## Appeal Decision

**Appeal Ref: APP/R5510/W/24/3355184**

**94 Cowley Mill Road, Hillingdon Uxbridge UB8 2QD**

- The appeal is made under section 78 of the Town and Country Planning Act 1990 (as amended) against a refusal to grant planning permission.
- The appeal is made by Mr Amador Ispir against the decision of the Council of the London Borough of Hillingdon.
- The application Ref is 14364/APP/2024/2390.
- The development proposed is the retention of a timber framed canopy.

DRAWING  
**EXISTING AND RETROSPECTIVE ELEVATIONS**

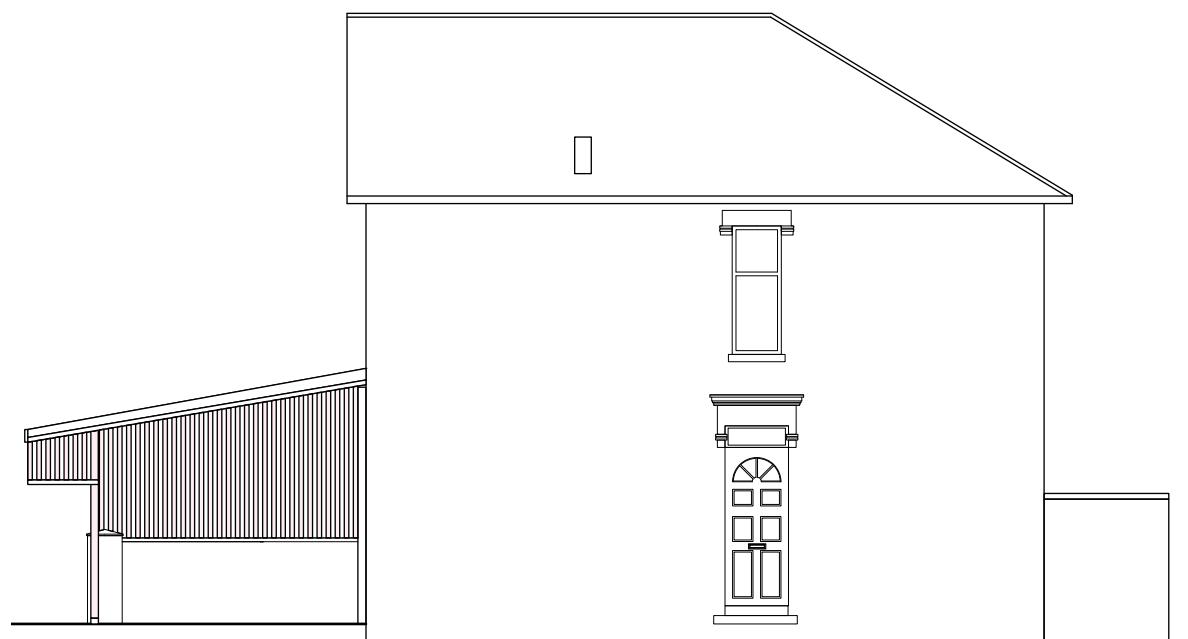
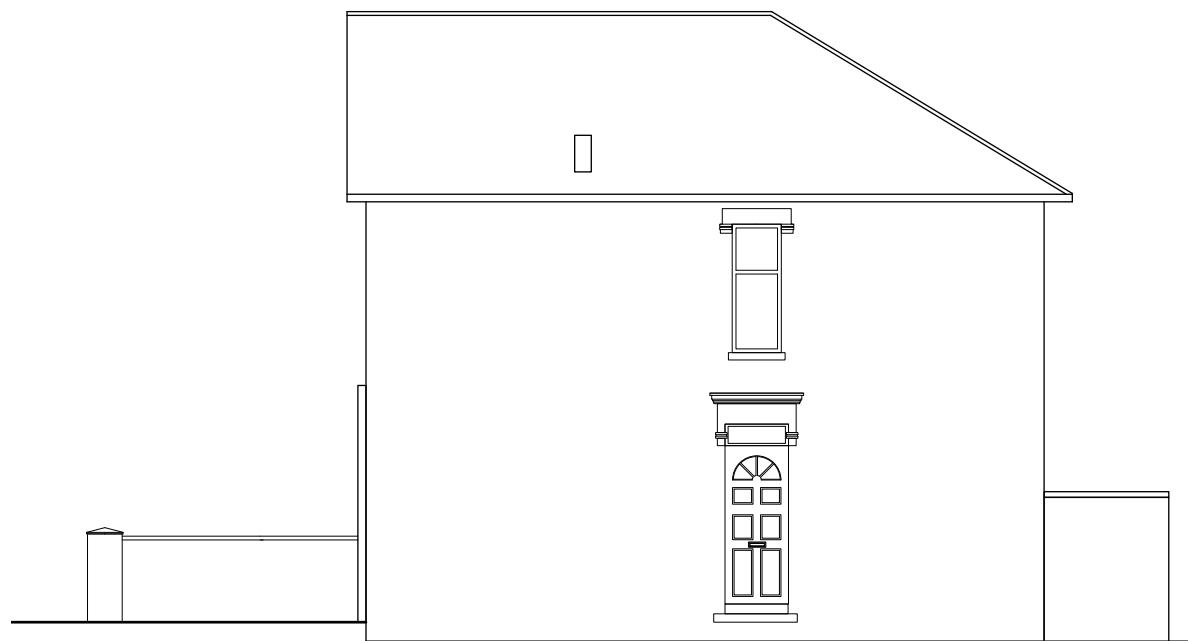
largely open along its southern elevation, the canopy does incorporate some hit and miss timber panelling along the top, which conceals some of the detailing of the shop front and is unsympathetic to the appearance of the appeal property.

7. The western elevation of the canopy is enclosed by a tall solid timber panel which is nearly the full depth of the frontage to the appeal property. This disrupts the prevailing arrangement of low-lying boundary treatments and dominates views along parts of Cowley Mill Road. Moreover, the prominent siting and bright colour of part of the canopy does not assist this to assimilate with the appeal property and wider street scene. Thus, the canopy appears unduly incongruous.

10. As the appellant has submitted the application, the onus is on them to show that this does not harm the living conditions of neighbours. To the west and attached to the appeal property is No. 93, a dwellinghouse. Because of the scale and form of the western elevation of the canopy, this encloses most of the shared boundary between the appeal property and No. 93. Consequently, due to its proximity and size, the western elevation of the canopy, to an extent dominates views from the principal window and entrance for No. 93. For these reasons and its orientation, the western elevation of the canopy is also likely to reduce the amount of daylight received to the principal window at No. 93 and cause some overshadowing of this.

12. Because the canopy only extends over the frontage, this does not impact the visibility of drivers and pedestrians exiting Mill Avenue. However, the western elevation of the canopy does reduce visibility for pedestrians leaving No. 93 and travelling west along the pavement, leading to potential conflict with other pavement users.
13. On the information before me, the frontage was previously available for vehicle parking. However, this area now appears to be used by customers of the beauty salon for waiting and relaxing before and after their treatments.
